# ROAD SAFETY AUDIT RESPONSE REPORT

**December 2014**

Location:	Southam Road, Banbury	Scheme:	Supermarket Development
Drawing numbers:	26004/2001/001	Project number:	26004
Site visit:	Yes Date: 02-12-14	Weather:	Cold with light rain fall

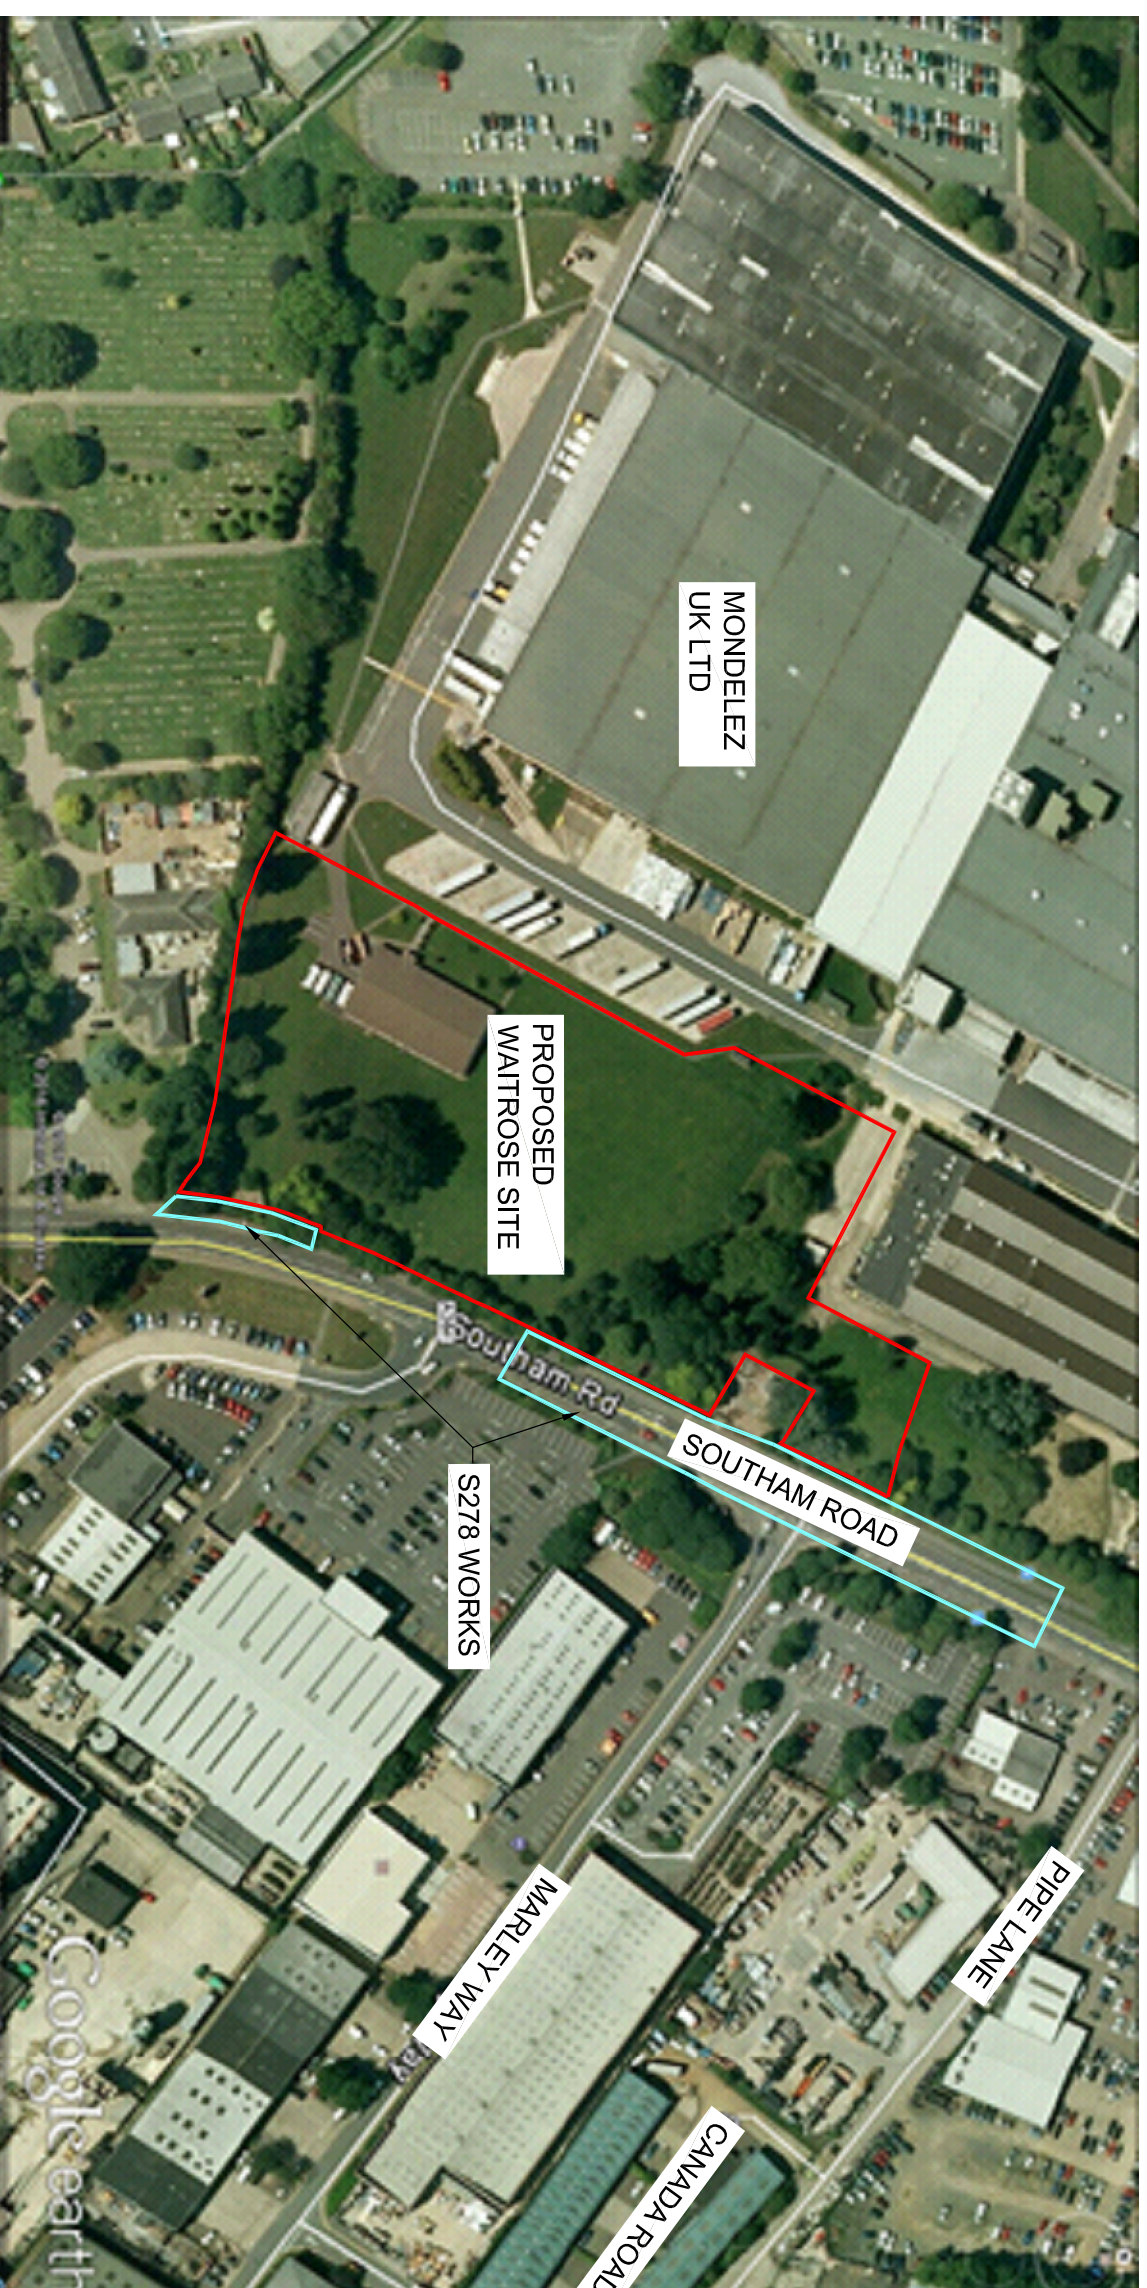
2.5	<p><b>Summary - Vulnerable pedestrians in danger of being struck by other road users</b></p> <p>Stage 1 RSA Recommendation</p> <p>Uncontrolled crossing points should be provided inset into the minor roads. If possible, the corner radii forming the junctions should be reduced in order to locate these crossing points closer to the direct NMU desire line.</p> <p>Appropriate tactile paving should also be provided as part of the details of the pedestrian ramp and steps between Southam Road and the car park.</p>	<p>This will be reviewed at detailed design stage, and appropriate crossing details provided.</p>

### SERVICE YARD ACCESS

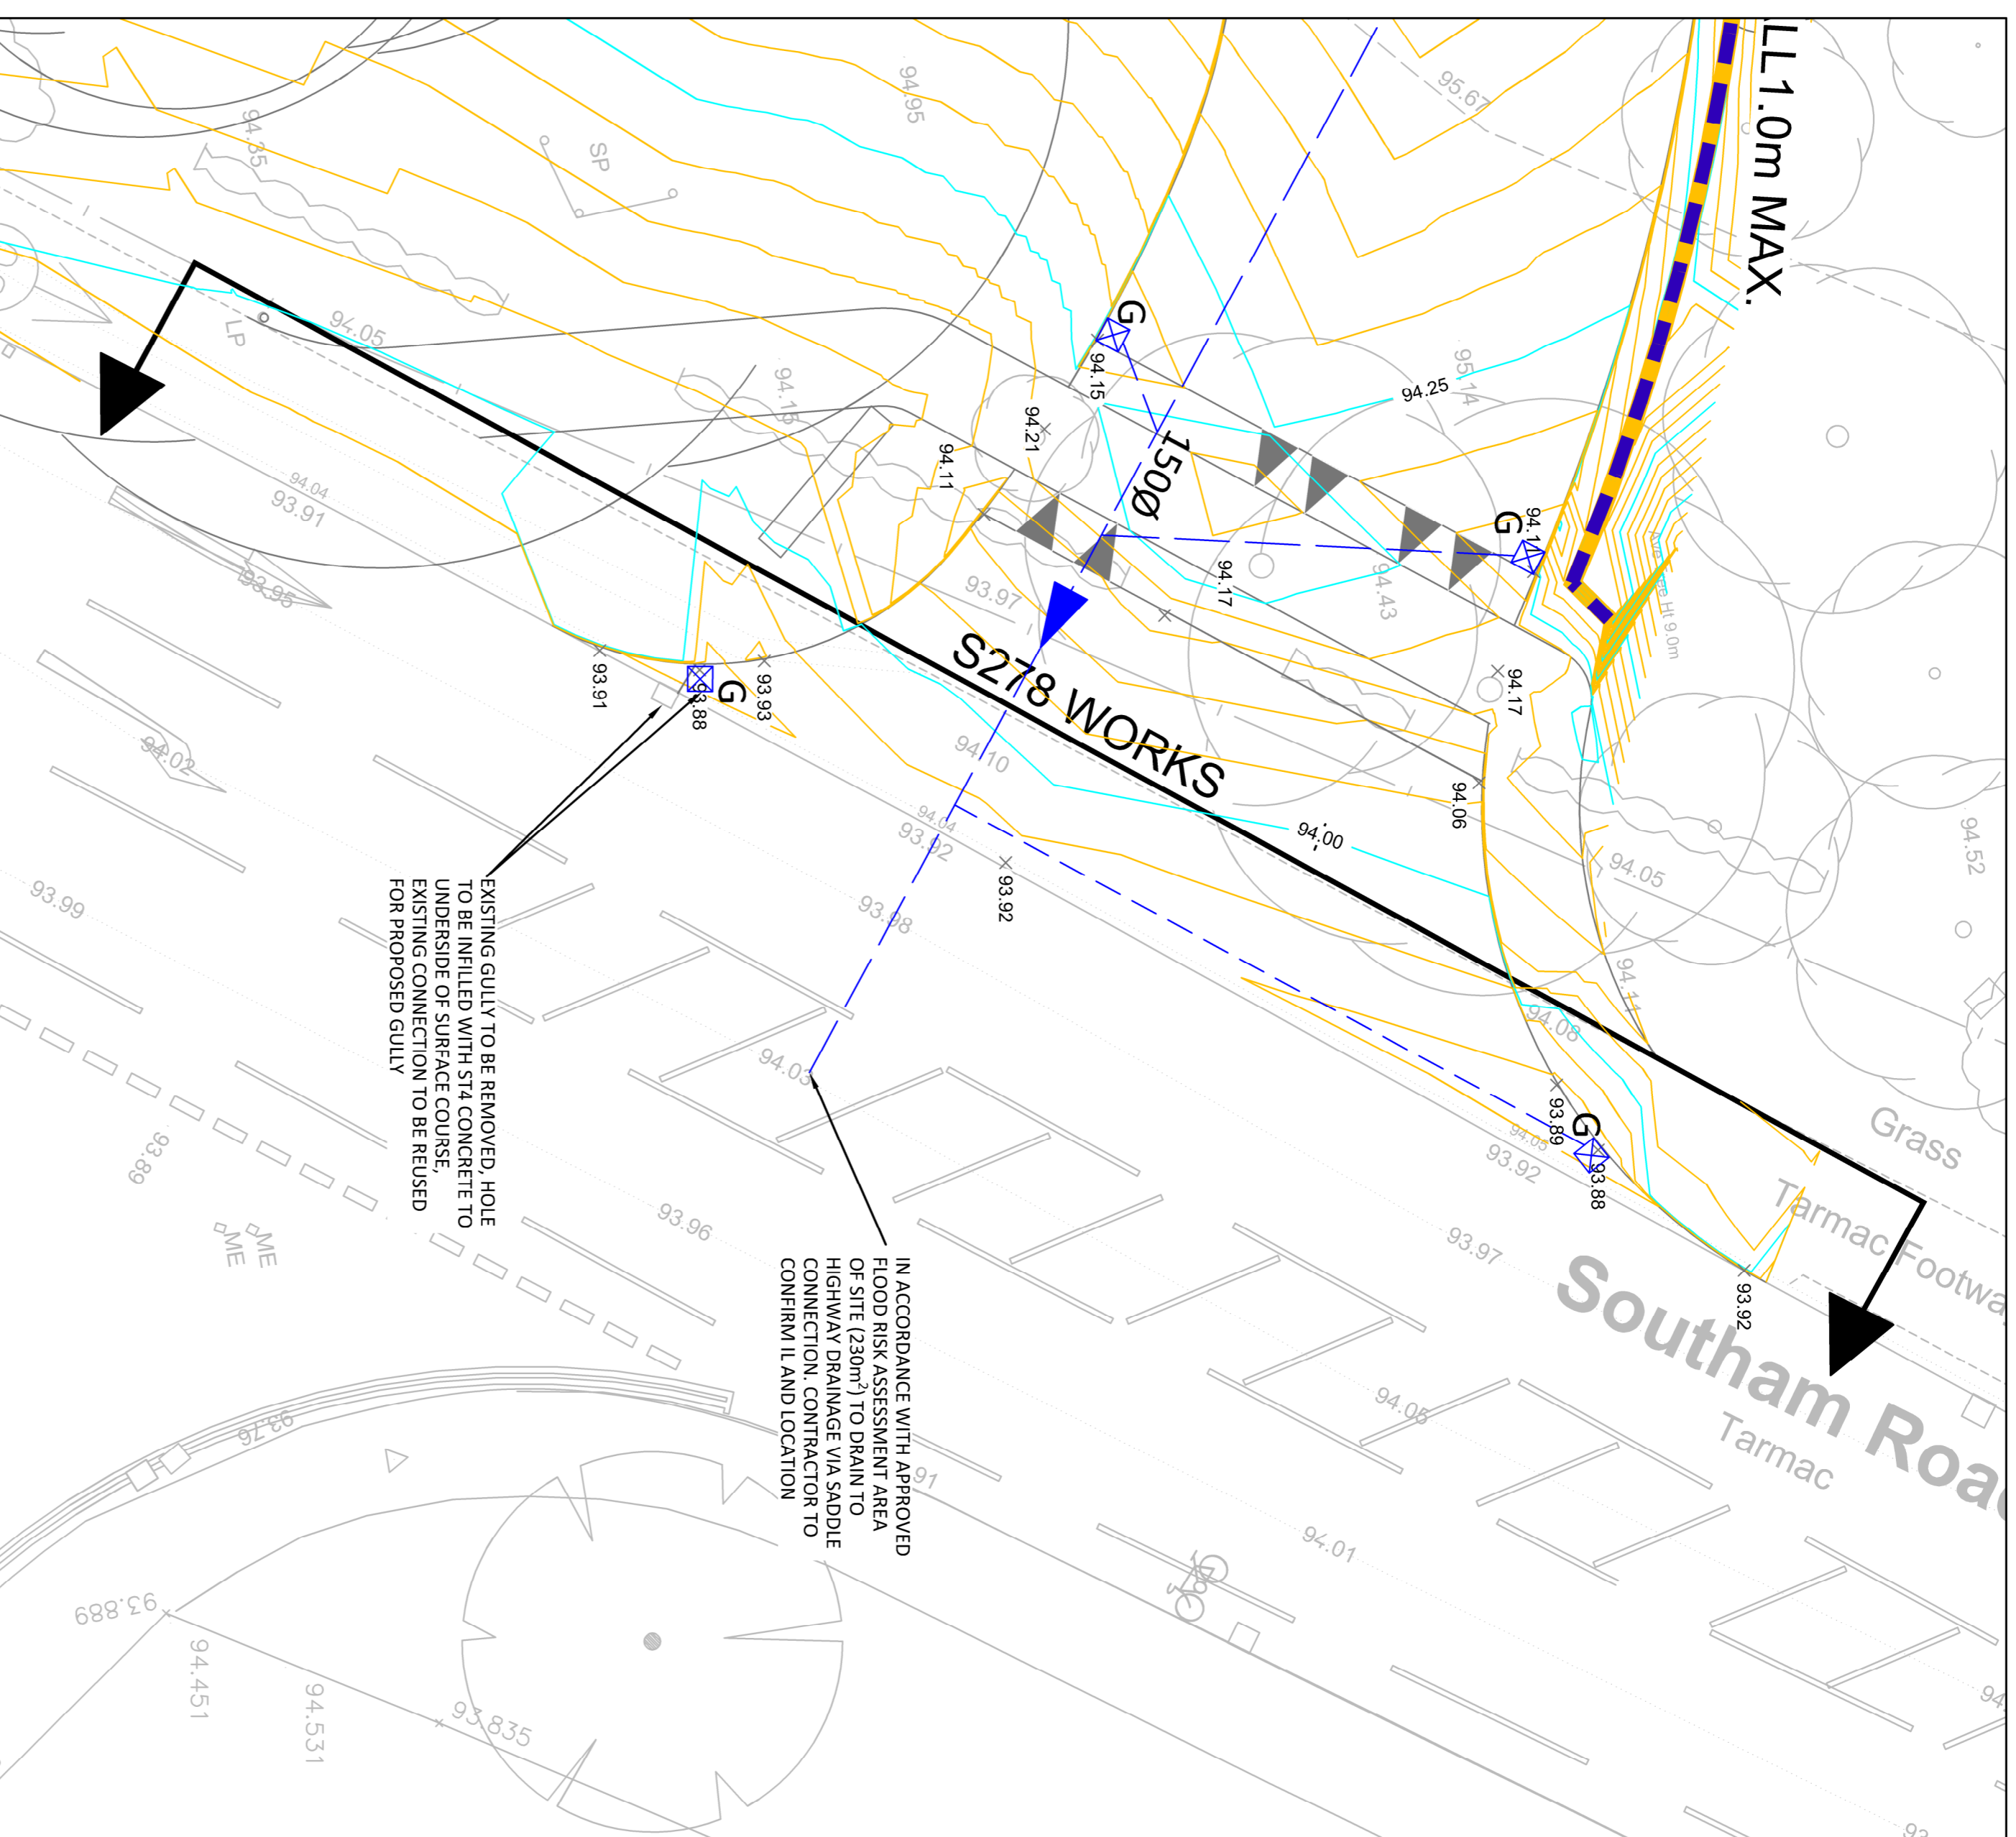
2.3	<p><b>Summary - Insufficient width of proposed turning lane leading to shunt and side swipe collisions</b></p> <p>Stage 1 RSA Recommendation</p> <p>The width of the turning facility should be increased in order to comply with the requirements stated within Mandatory Item 7.35 of TD 42/05 for this new junction</p>	<p>After further assessment, there is sufficient room to accommodate a 3m right-hand turning lane for the entire turning length as stated in Item 7.35.</p> <p>The design will be reviewed at detailed design stage as required.</p>
